# A12 Chelmsford to A120 widening scheme

## 9.41 Applicant's Responses to ExQ2

**Applicant's Responses to ExQ2**

<b>Regulation Number</b>	Rule 8(1)(c)(ii)
<b>Planning Inspectorate Scheme Reference</b>	TR010060
<b>Application Document Reference</b>	TR010060/EXAM/9.41
<b>Author</b>	A12 Project Team and National Highways

- Order Limits
- Proposed Scheme Centreline
- Modelled Road Network
- Change in NO₂ Concentration (µg/m³)**
- >4 reduction
- >2 to <=4 reduction
- >0.4 to <=2 reduction
- <=0.4 change
- >0.4 to <=2 increase
- >2 to <=4 increase
- >4 increase

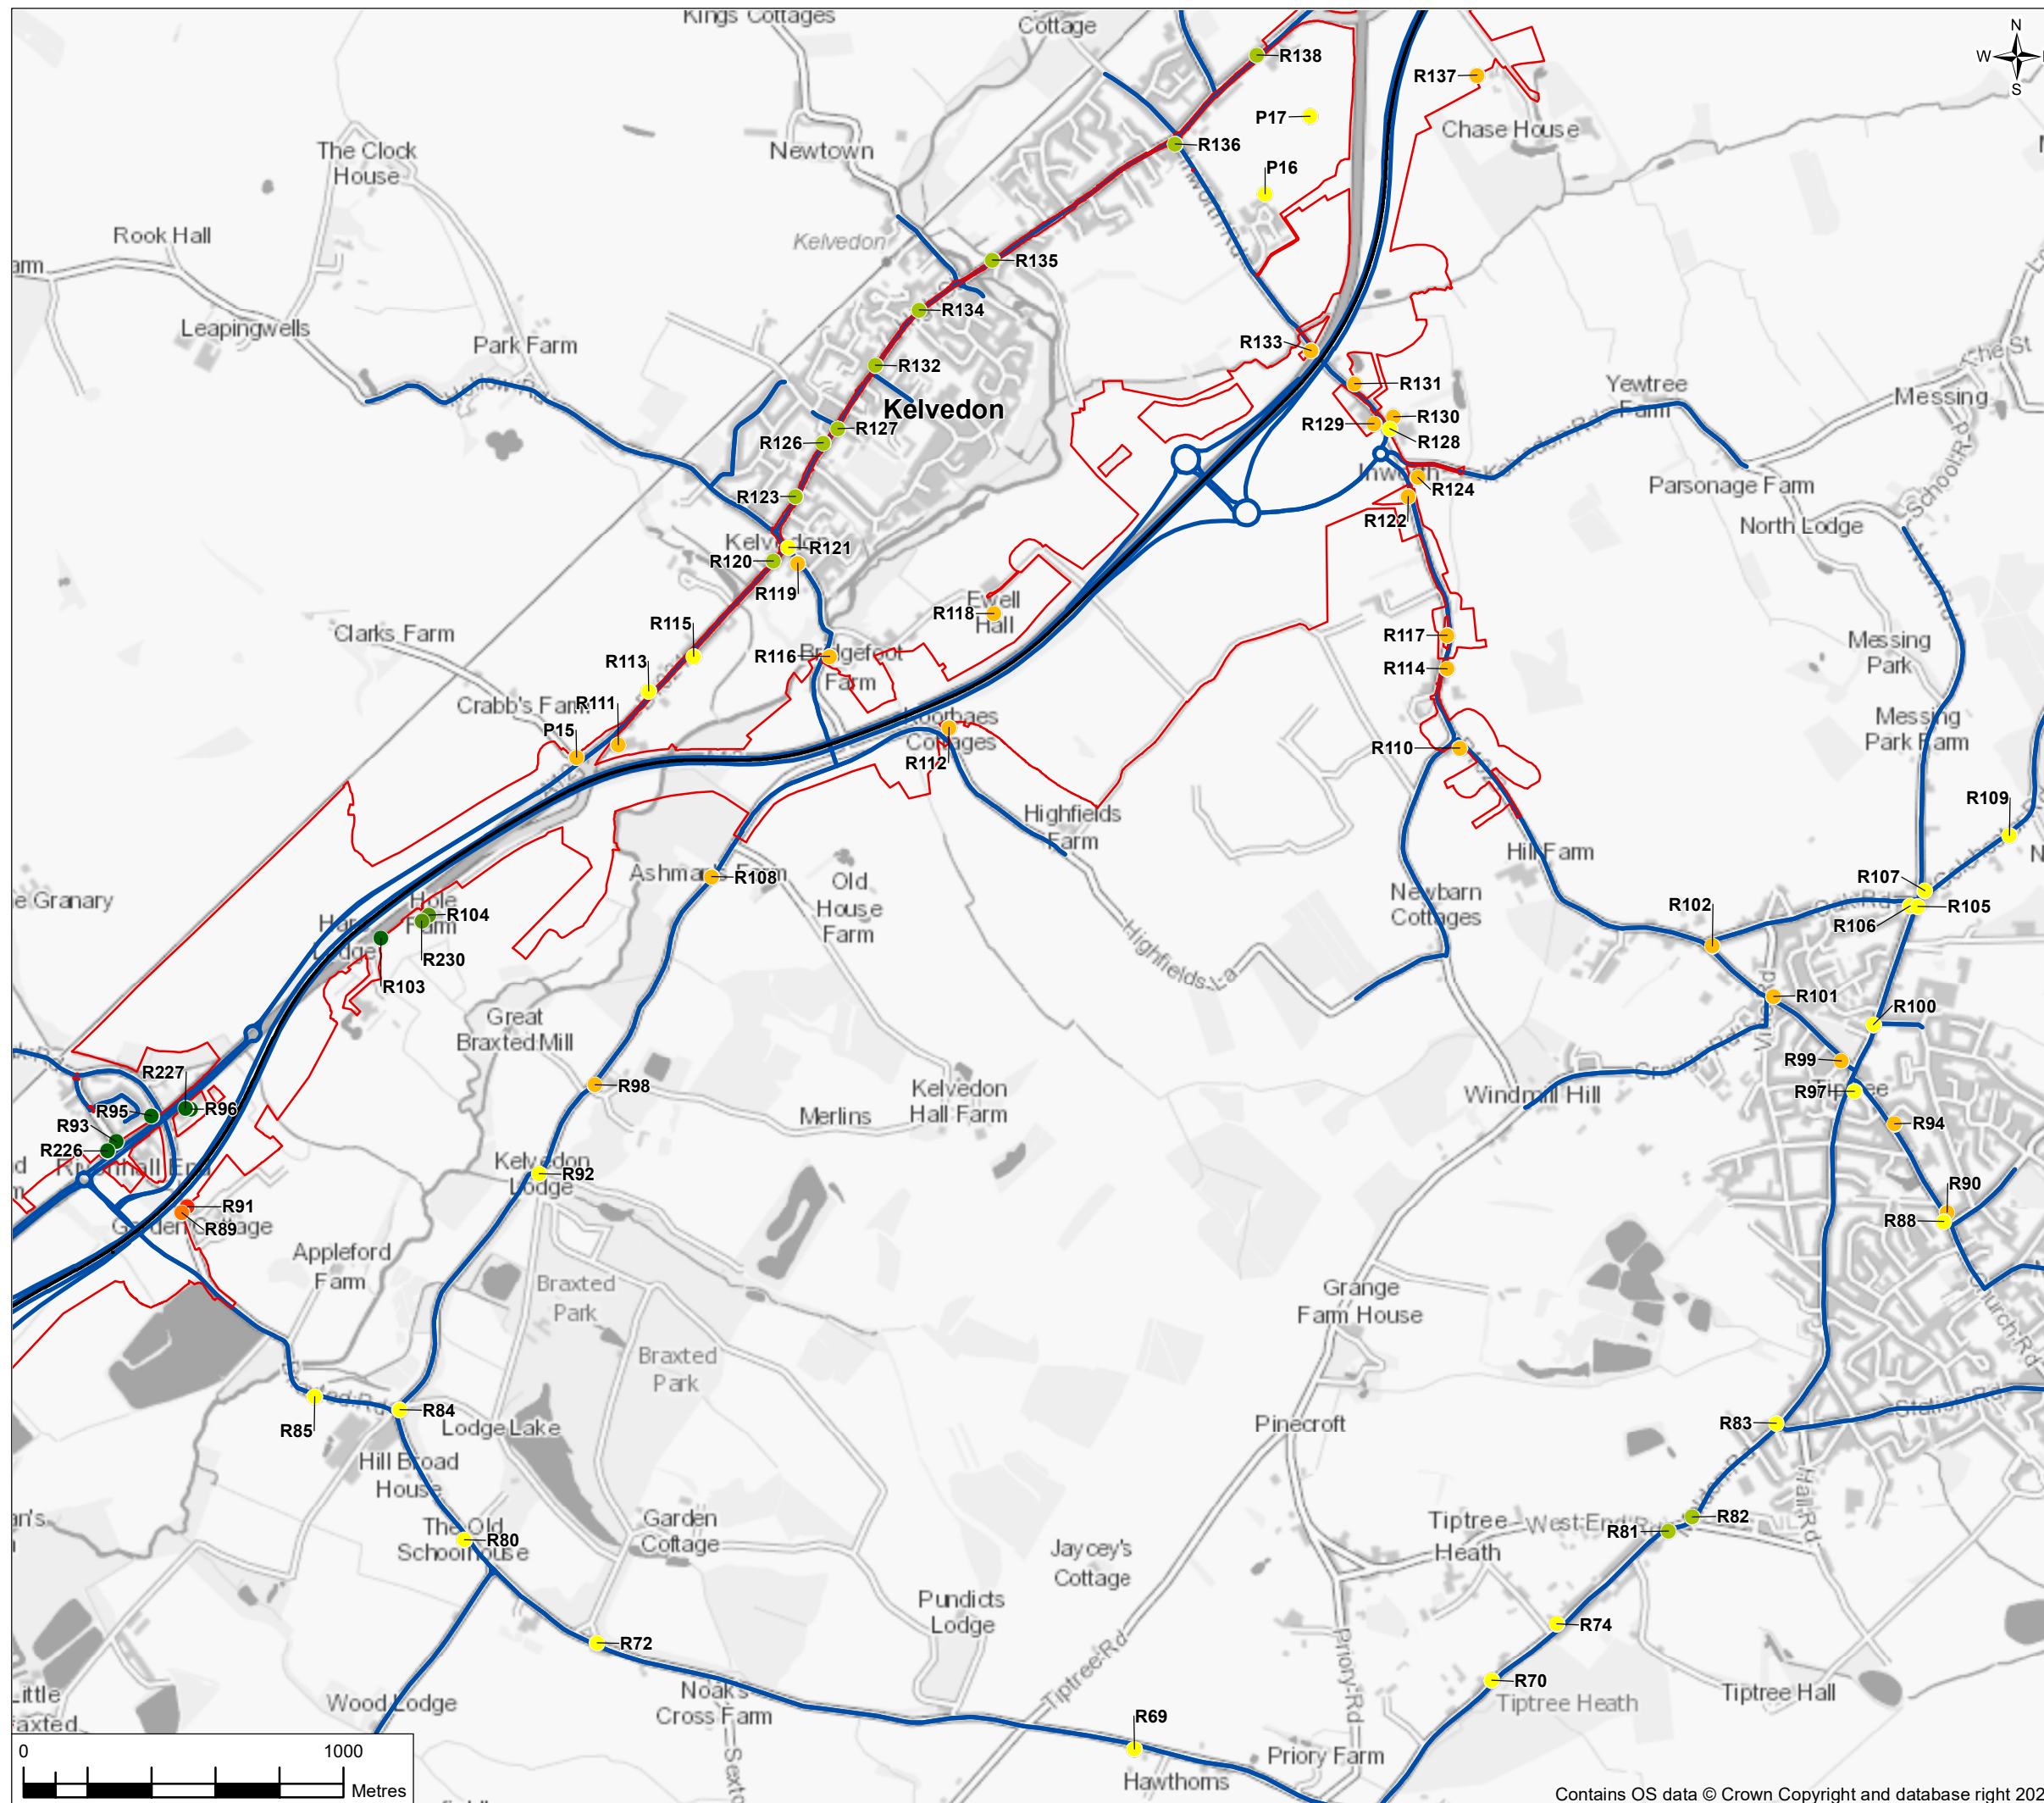
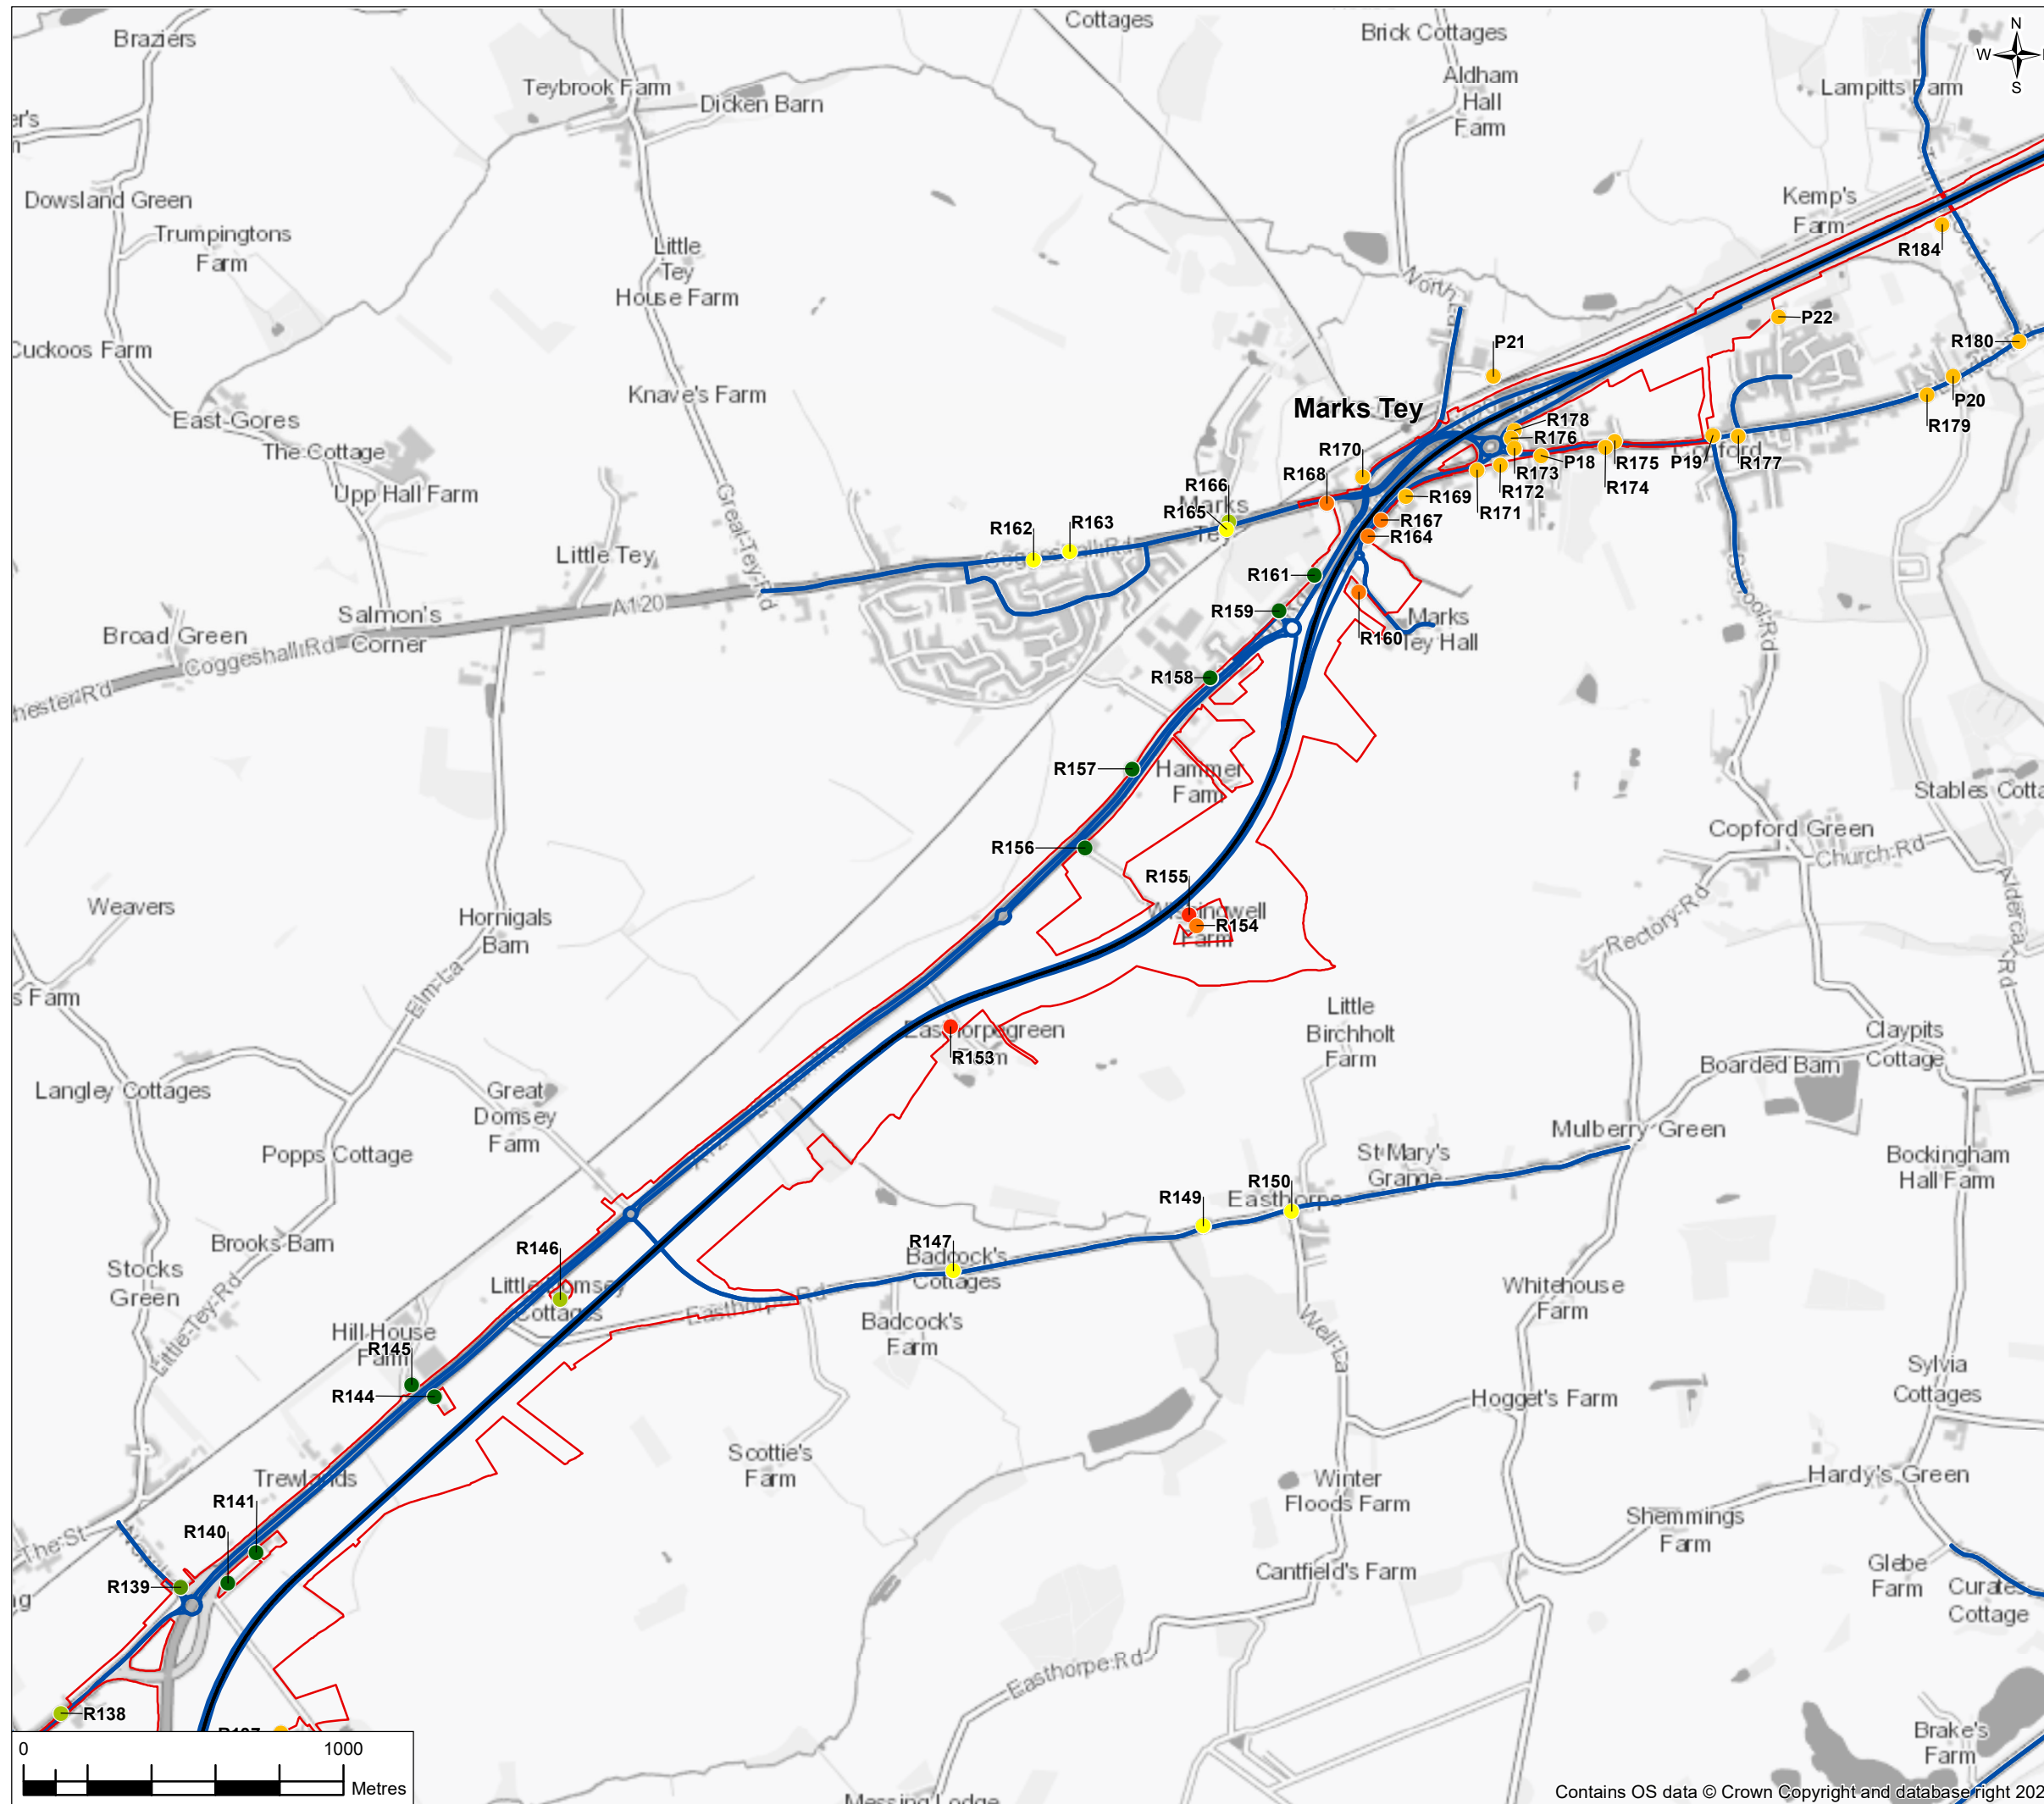
ES Chapter 6 [APP-073], Air Quality, identifies that during the peak construction year, two human health receptors (R189 and R193) were found to be at risk of exceeding the annual mean NO<sub>2</sub> Air Quality Objectives (AQO). These receptors were also shown to exceed the threshold once the Proposed Development is operational. Given that in both instances levels are predicted to exceed AQO during both construction and operation, notwithstanding details already submitted, please can the Applicant provide more justification as to why the need for an Air Quality Management Area (AQMA) and associated Project Air Quality Action Plan (PAQAP) is not triggered at these locations.

The air quality modelling predicted exceedance of the NO<sub>2</sub> annual AQO at two human health receptors (residential properties referenced as R189 and R193) during the peak construction year 2025 and in the opening year 2027 both with and without the proposed scheme. The increase in NO<sub>2</sub> was classed as imperceptible in the construction year (i.e. <0.4µg/m<sup>3</sup>) and small in the opening year (i.e. >0.4µg/m<sup>3</sup> and <2.0µg/m<sup>3</sup>) (see Chapter 6 Air Quality Table 6.16 in the Environmental Statement [APP-073]). A third human health receptor R225 was also found to exceed the NO<sub>2</sub> AQO in the opening year for the with scheme scenario but not in the no scheme scenario. In this case the increase in NO<sub>2</sub> concentration was classed as medium (i.e. >2.0µg/m<sup>3</sup> and <4.0µg/m<sup>3</sup>). Further information on these assessments is discussed within the Environmental Statement Chapter 6: Air Quality Assessment [APP-073] Section 6.9.

A conclusion of no significant effect was reached in relation to the impact of the proposed scheme at the project level. This conclusion applied the approach set out in DMRB LA 105 Table 2.92 whereby, for a given magnitude in predicted increase in NO<sub>2</sub> concentration, no significant effect at a project level was determined on the basis of the number of individual properties suffering a worsening of an existing exceedance and creation of a new exceedance. The numbers of receptors with medium and small exceedances predicted for the proposed scheme are well within the ranges provided in DMRB LA 105 Table 2.92.

For the proposed scheme, the Applicant considers that future exceedances are unlikely due to the conservative nature of the air quality model. In other words, the Applicant considers that the air quality results are over-estimating future NO<sub>2</sub> concentrations based on the uplift applied via the Long Term Trends Gap Analysis (LTTE6) in accordance with the DMRB LA 105. This analysis is discussed further in Section 1.15 of the ES Appendix 6.3: Dispersion Modelling Process [APP-102].

The Applicant considers that the most appropriate way forward would be to monitor NO<sub>2</sub> at the three locations to determine the actual NO<sub>2</sub> concentrations and compare them with the Annual Mean AQO of 40µg/m<sup>3</sup>. If, as expected, the NO<sub>2</sub> concentrations are below the AQO, there would be no need to declare an AQMA. Ideally the NO<sub>2</sub> monitoring should be conducted over 12 months to compare the results against the Annual Mean NO<sub>2</sub> AQO. However, monitoring over a shorter period (i.e. less than nine months) is also possible given that the results can still be annualised to obtain the annual monitored NO<sub>2</sub> concentration.
